**Consultation Response from: KC Environmental Health (Pollution & Noise Control)**

**2025/92888 - 71B - 71C Huddersfield Road, Holmfirth, HD9 3AZ**

**Installation of new shop front and X1 condenser unit (within a Conservation Area)**

**Responding Date:  
11 December 2025**

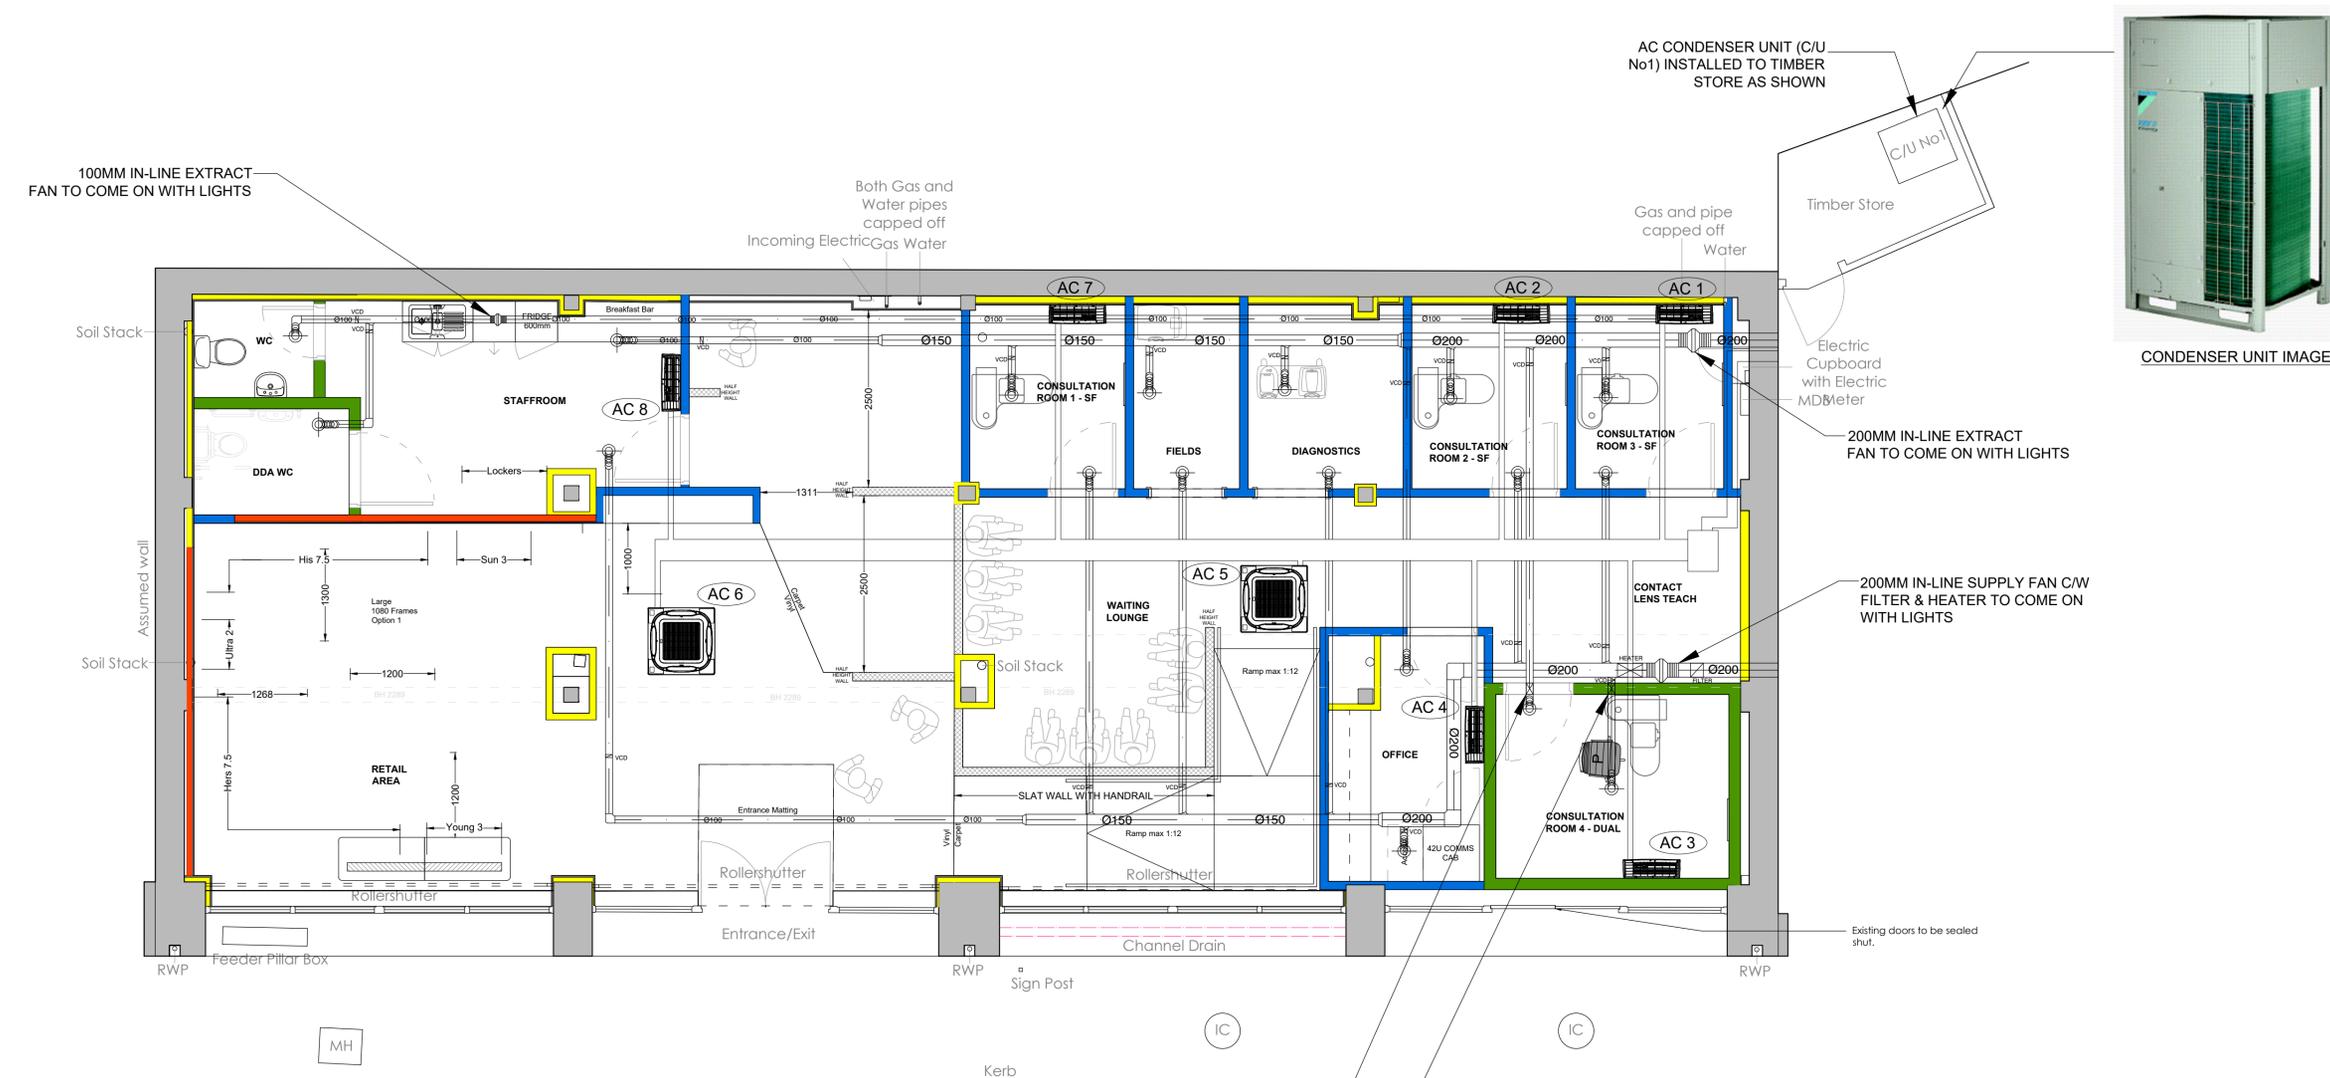
Para 4.2 of the submitted Design & Access Statement from Fisch Design states there are no clear residential properties in close proximity due to this being a retail location within the retail/commercial district. However, our mapping system shows immediate and neighbouring residential uses and we have concerns about a loss of amenity. The submitted HVAC plan from Fisch dated 20 September 2025 Ref 2546-01 also shows a number of internal fixed mechanical plant units i.e. A/C cassettes, inline fans, motorised damper etc. supporting our concerns.

A condition is recommended for the submission of a Noise Impact Assessment to address this concern.

Before construction work commences, a noise assessment report by a suitably competent person shall be submitted to and approved in writing by the Local Planning Authority. The report shall include:

- a) an assessment of all noise emissions from the proposed development
- b) details of existing background and predicted future noise levels at the boundary of the nearest noise sensitive premises
- c) a written scheme of how the occupants of the above-mentioned noise sensitive premises will be protected from noise from the proposed development including details of all necessary noise attenuation

The development shall not be brought into use until all works comprised within the measures specified in the approved report have been carried out in full and such measures shall be thereafter retained.
